**Sent:** 13 February 2026 17:50  
**To:** DC Admin  
**Subject:** Planning objection Application - 2025/60/93572/E  
**Attachments:** STATEMENT OF OBJECTION 130226.pdf; Cumberworth landscape constraints.pdf

**Application Ref:** 2025/60/93572/E

**Proposal:** Outline application (all matters reserved except access) for up to 123 dwellings

**Site:** Upper Cumberworth

Layout For Illustration Purpose Only.

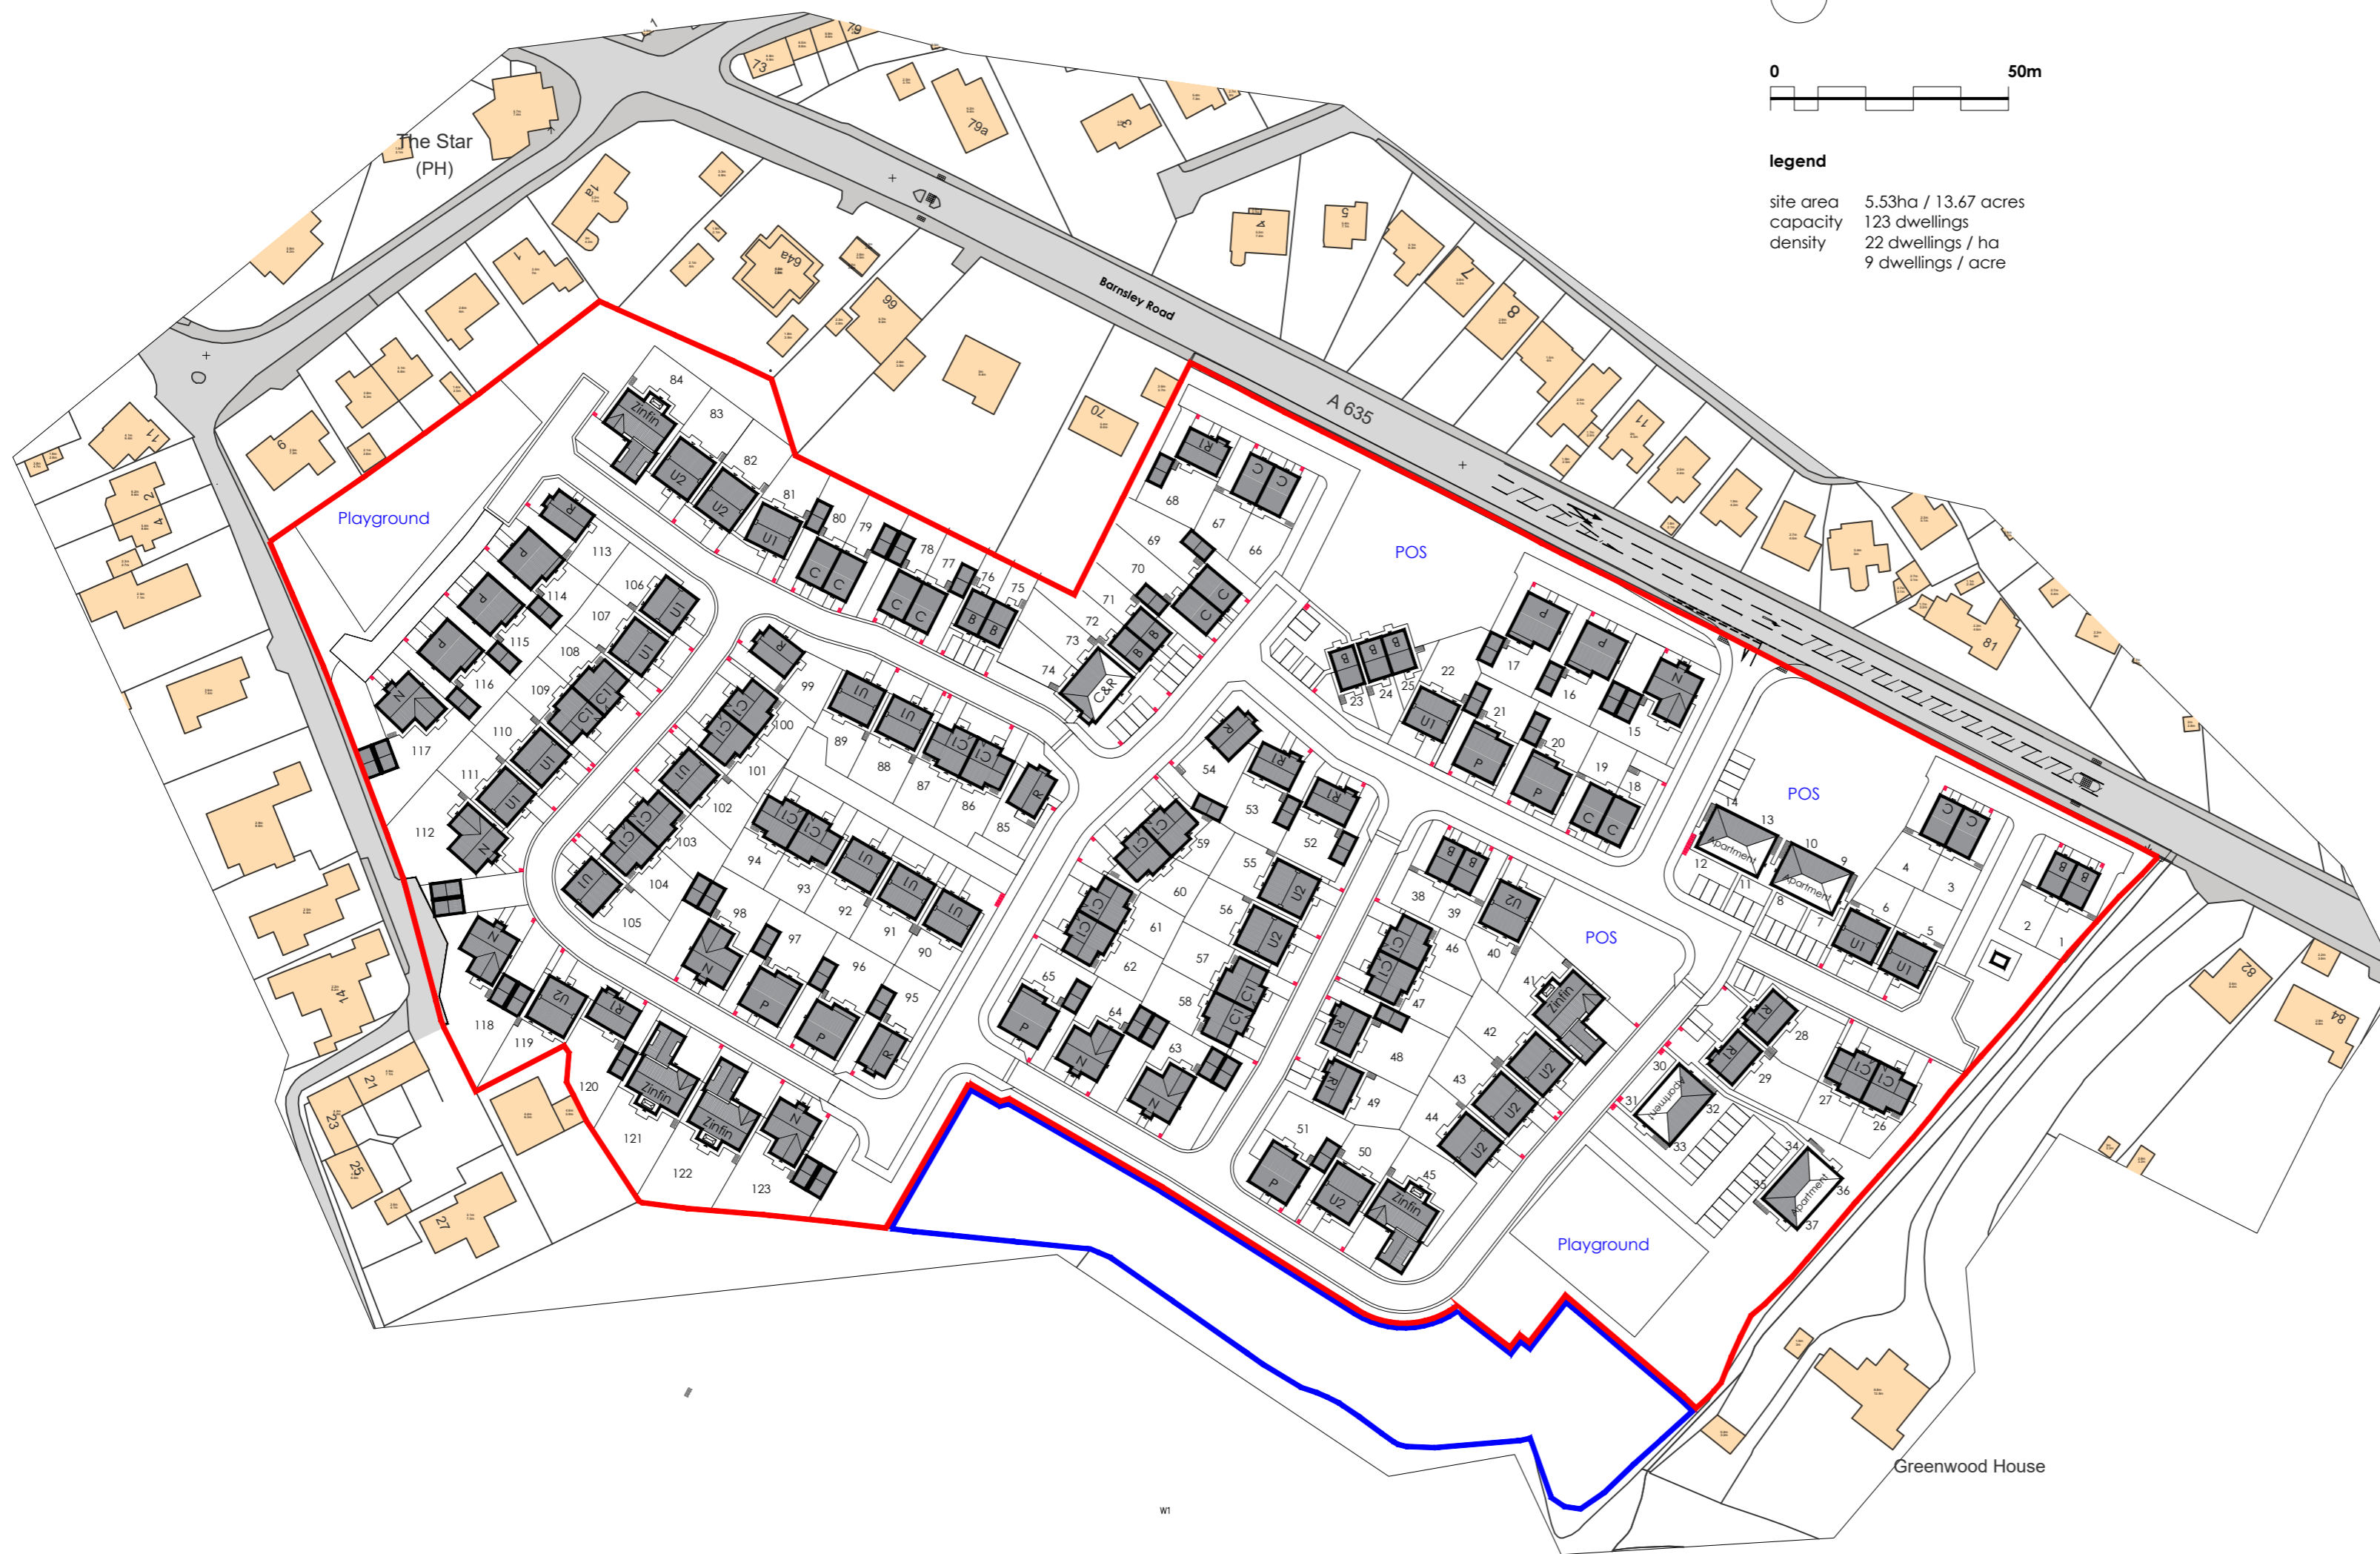
Furthermore, I would like to make a comment regarding the location plan (application boundary) this is incorrect and requires some clarification regarding the use of 2 matters

1. The buffer zone, this should be included within the application red line.
2. The parking solution and turning head required at Park Lane.

The illustrative layout demonstrates:

- Insufficient parking provision for certain plots
- Loss of existing parking for Lane Head Farm and Weavers Cottage
- Overreliance on on-street provision

Issues include:

- Inadequate separation distances
- Reduced garden depths
- Overlooking potential
- Two-storey massing adjacent to predominantly bungalow character
